Application reference number	2025/0947
-------------------------------------	-----------

Application Type	Listed Building Consent
-------------------------	-------------------------

Proposal Description:	Renewal of external lighting and installation of CCTV (Listed Building Consent)
Location:	Northern College, Lowe Lane, Stainborough, Barnsley, S75 3ET

Project: **WENTWORTH CASTLE**
 Title: **ELECTRICAL SERVICES SITE PLAN EXTERNAL LIGHTING REQUIREMENTS**
 Client: **NORTHERN COLLEGE**

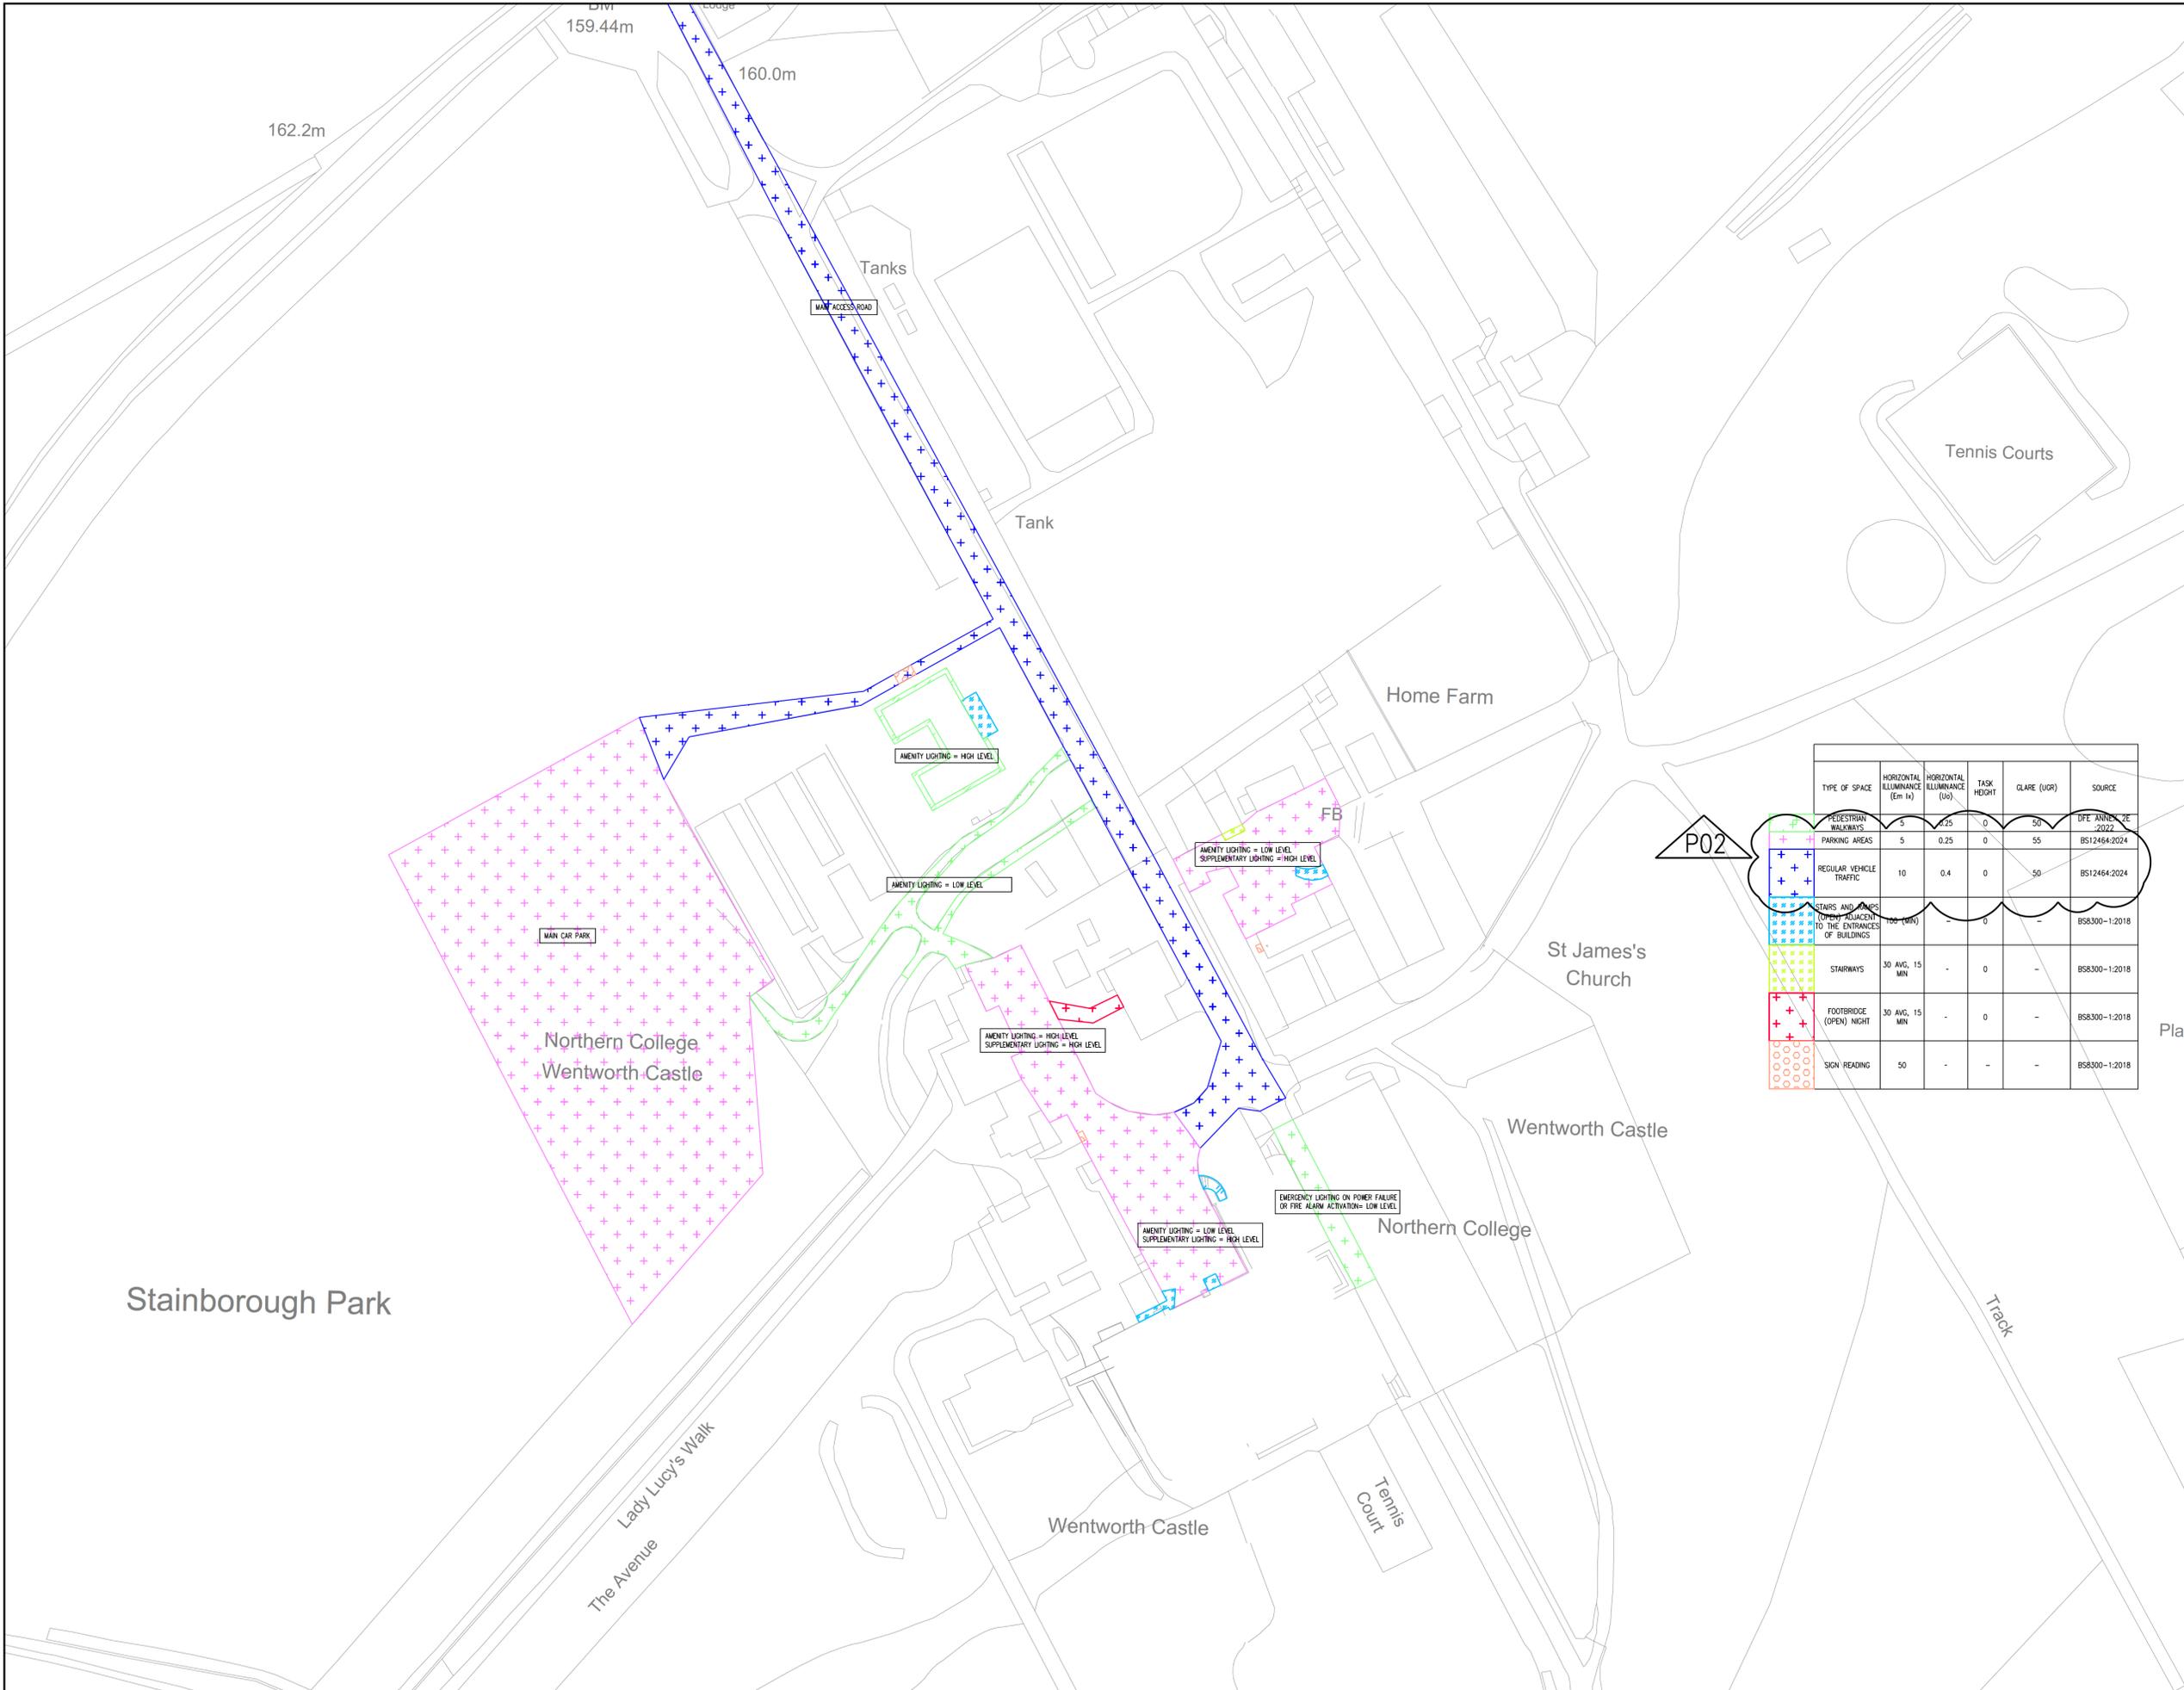
- Lighting columns – the number of units feels unnecessary at this scale and new brighter fittings could be harmful to the wider significance of the registered park and garden and have a visual impact which is harmful to the significance of the building. The applicant has not demonstrated whether there could be a less harmful solution that could reduce or mitigate harm.

- Lighting columns: most lights are replacements and designed to reduce light outputs which will reduce impact on ecology. There will be less general lighting than existing, apart from the Baroque frontage which will be lit in emergency only. The lighting here is required to light the fire emergency egress route. Other fitting would not light the landing or steps or would be inappropriate (eg bulkhead fittings).

The application is supported by an ecology covering letter which concludes that some areas of the site will see higher levels of lighting for the purposes of health and safety. However, this has been offset by the proposed use of warm white lighting across the site, the removal of uplighting and a reduction in lux levels along the drive. The Council's Ecologist confirms that they are content that the proposals will not result in additional negative impacts upon bat foraging, commuting and roosting habitat.

IP CCTV SYSTEM

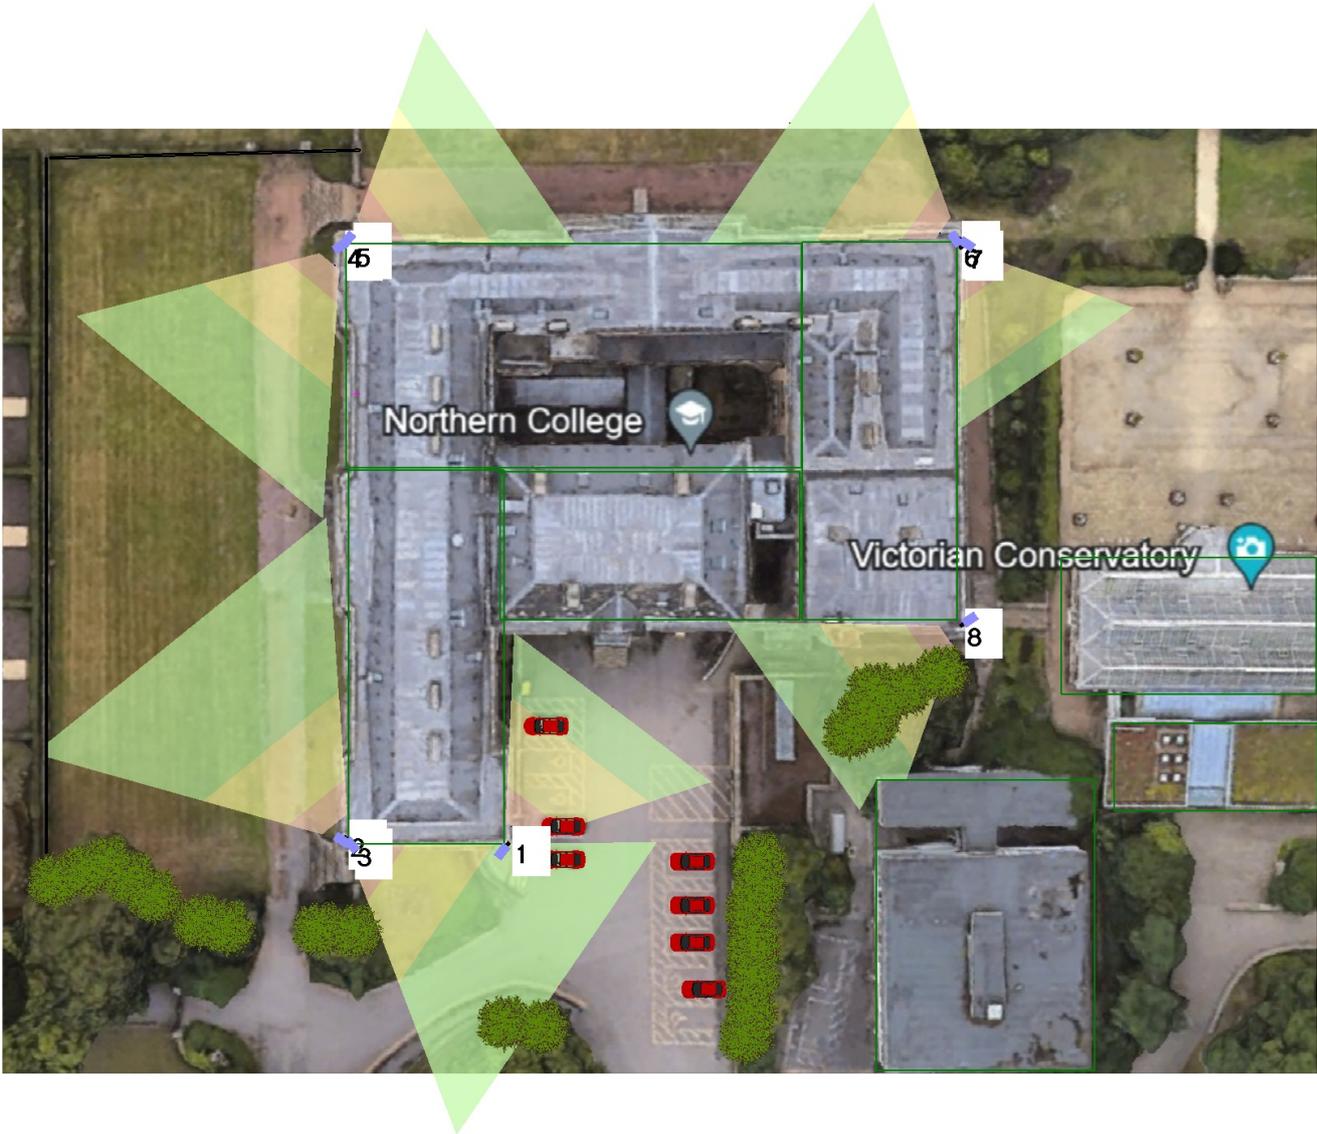
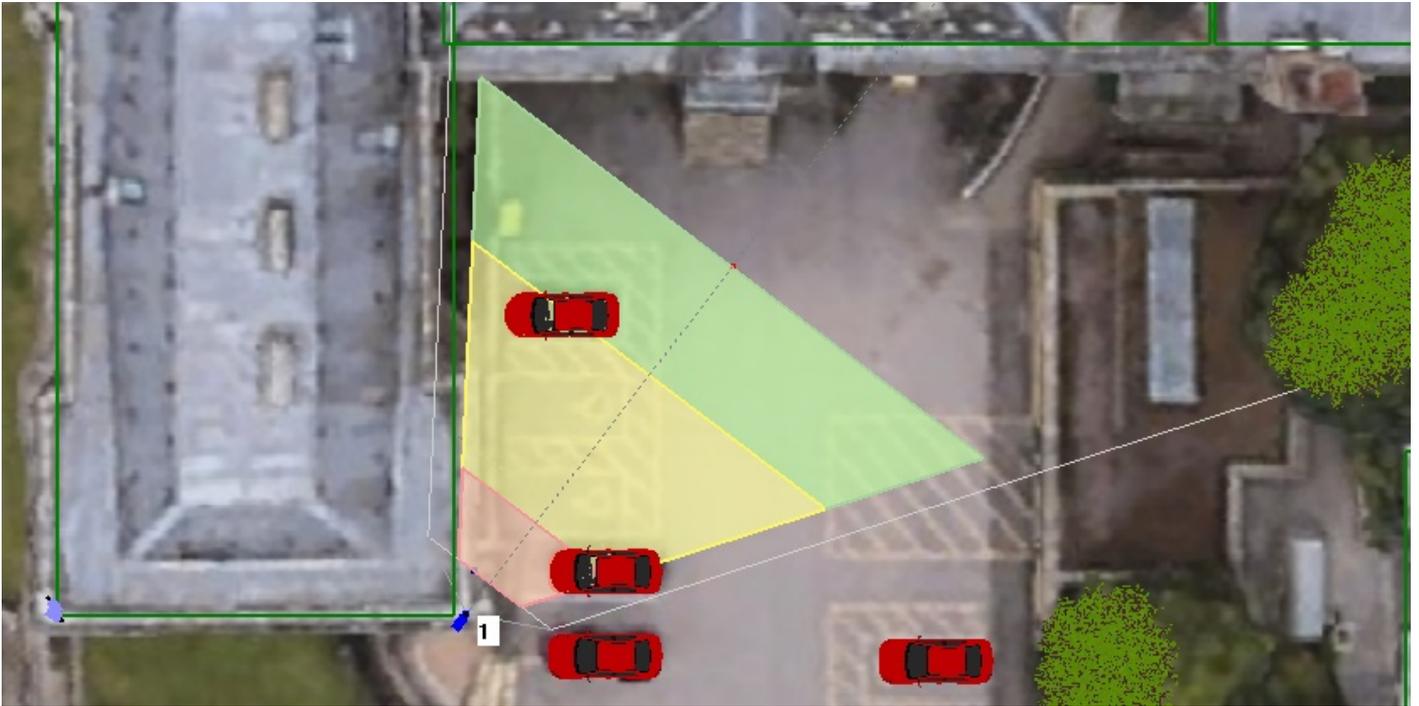
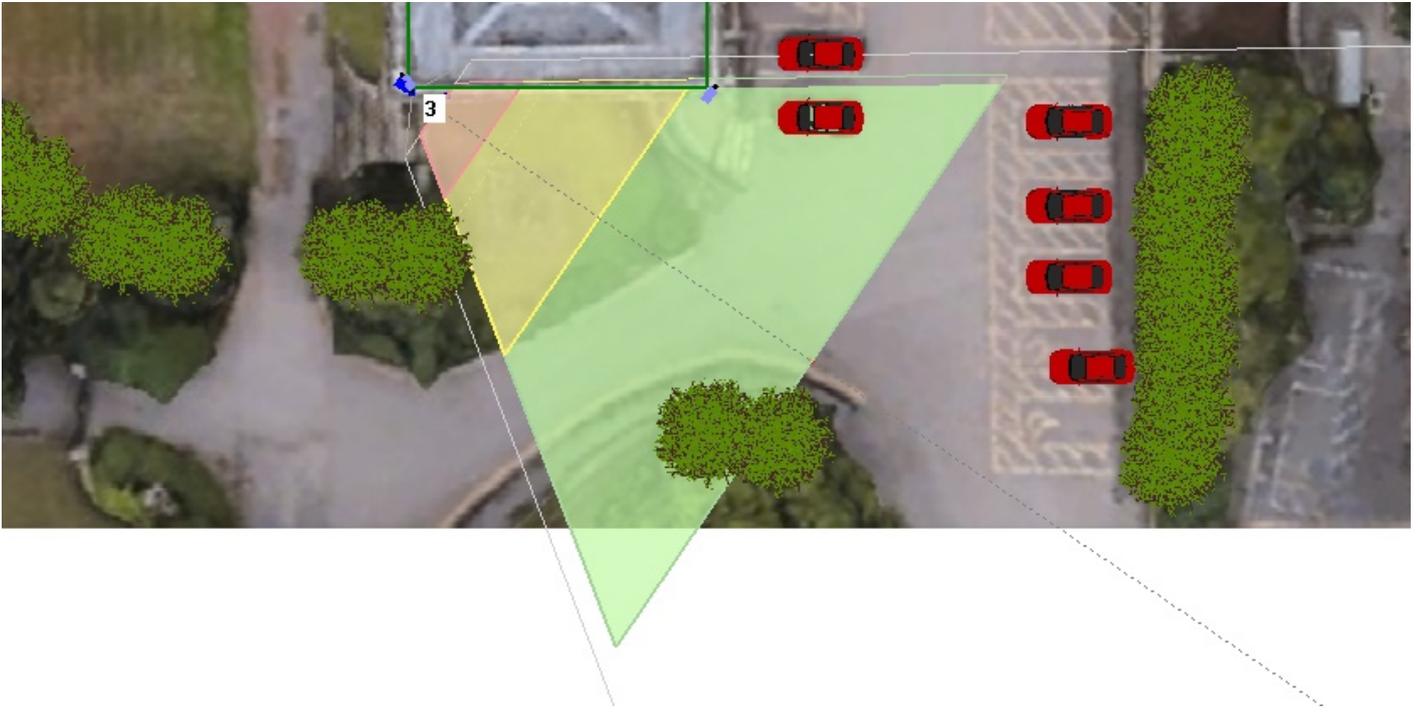
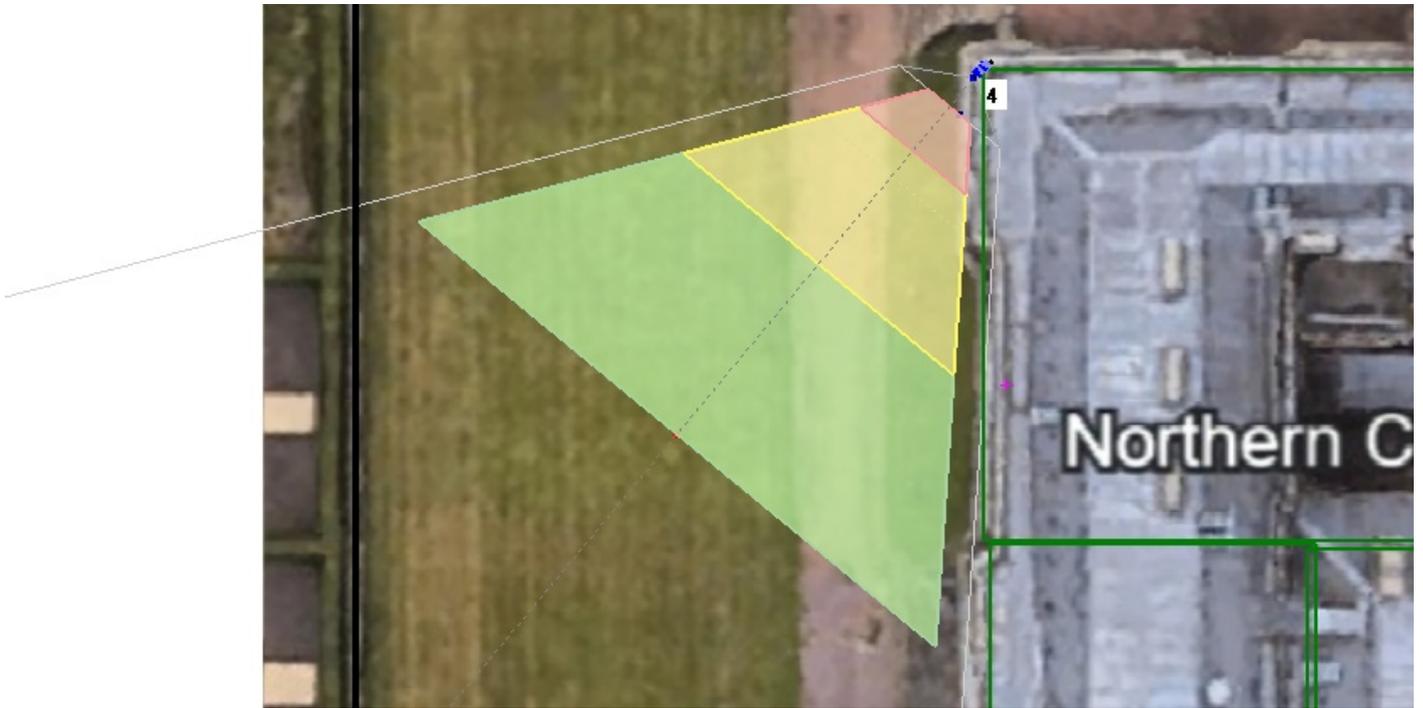
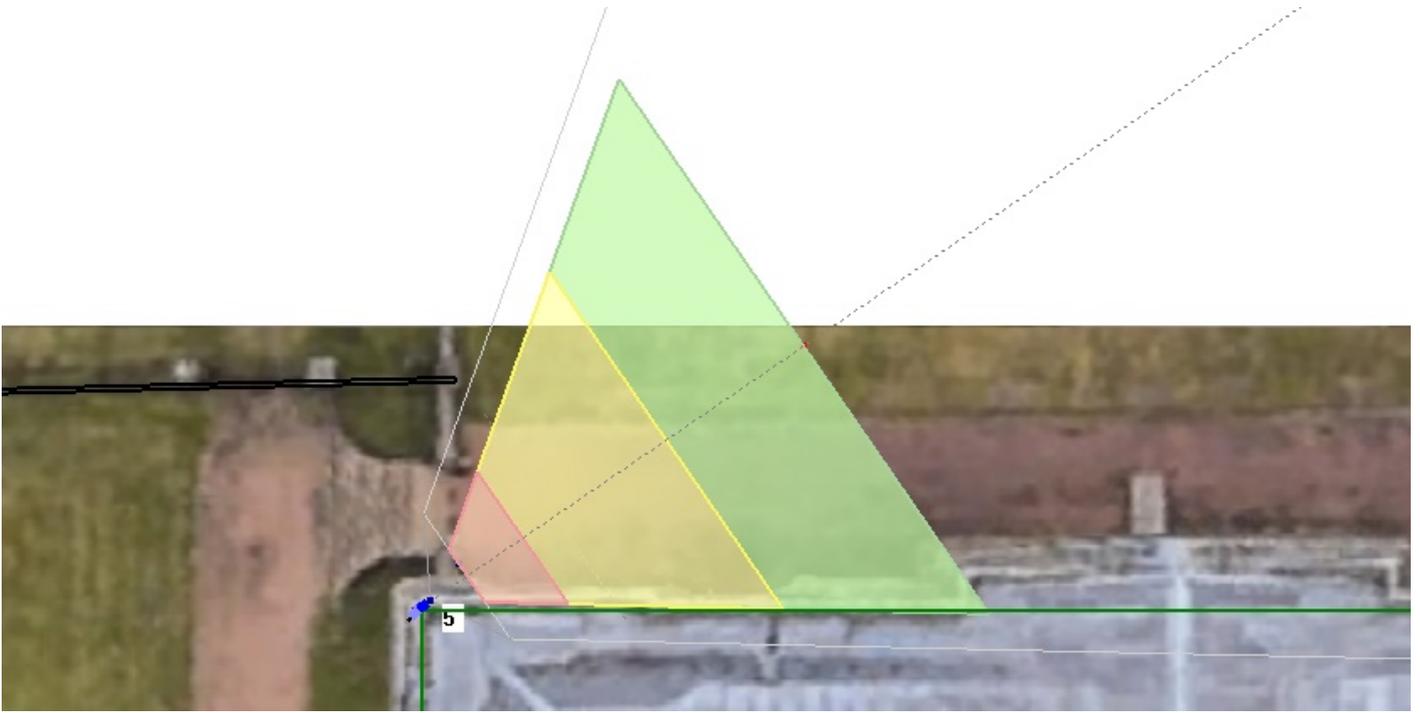
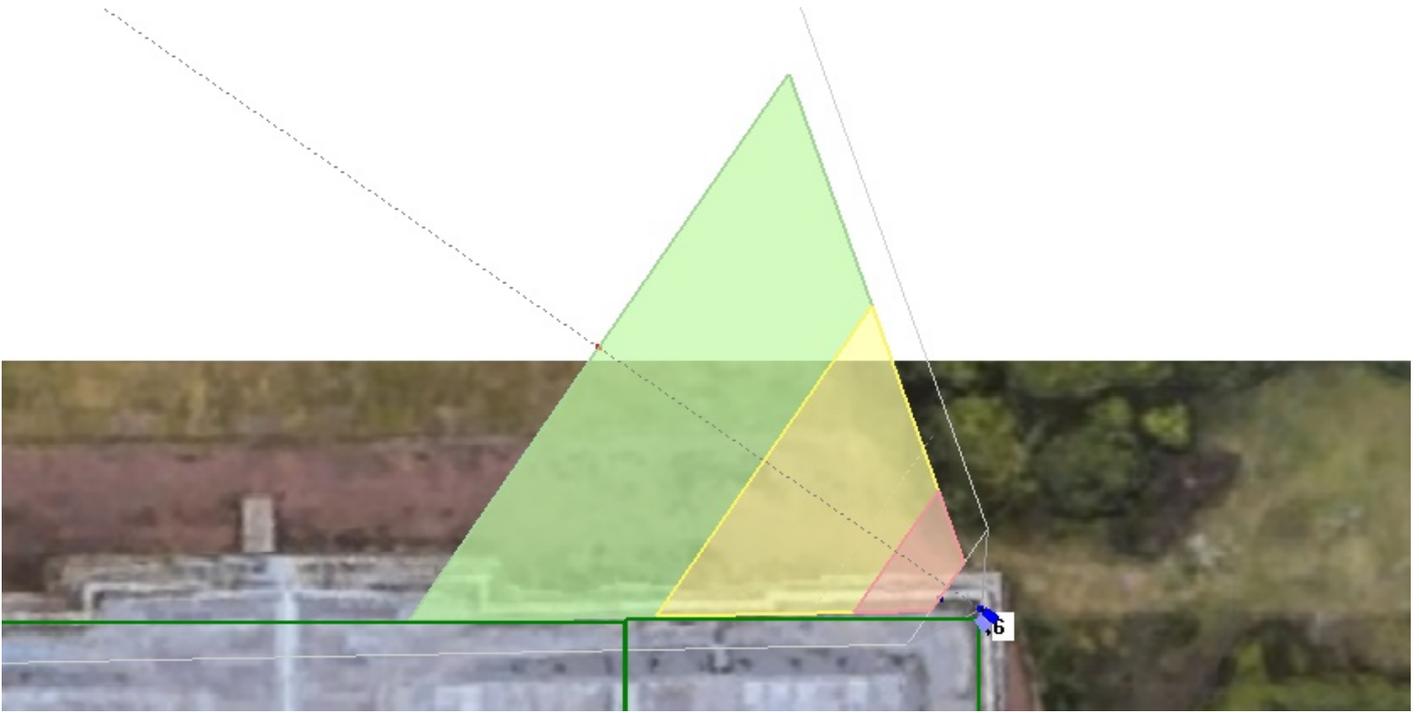
- CCTV cameras: proposed as there have been safeguarding concerns with people accessing the college grounds from adjacent land. The intention is for cameras to view approaches to the college within the college grounds and not look into the landscape beyond.

- CCTV cameras – general concerns are expressed regarding the number of cameras facing National Trust leased land and whether these are necessary or justified. The elevations submitted for the proposed CCTV cameras identify locations as indicative only and the status of the plan should be clarified to safeguard the significance of the building. A method statement should be provided to control/prevent harm to the building.

The Council's Conservation Officer initially expressed concerns at the impact of the proposed works, in particular on the Baroque Wing East Elevation, where proposed lighting causes less than substantial harm to the significance of this Grade I listed building and its setting. Following discussions with Historic England and the agent, it was concluded that the proposal is justified because alternative options needed greater physical intervention to the building, or were impractical; and that the proposed lighting solution represents the least harmful option, providing necessary illumination to the stone staircase in the event of a fire. Conditions are recommended to ensure that the replacement lighting units are fitted using existing fixtures and fittings; to require new lighting units to be fitted within the joints of the stonework; and to require the cameras to be black and fitted within the joints of the stonework.
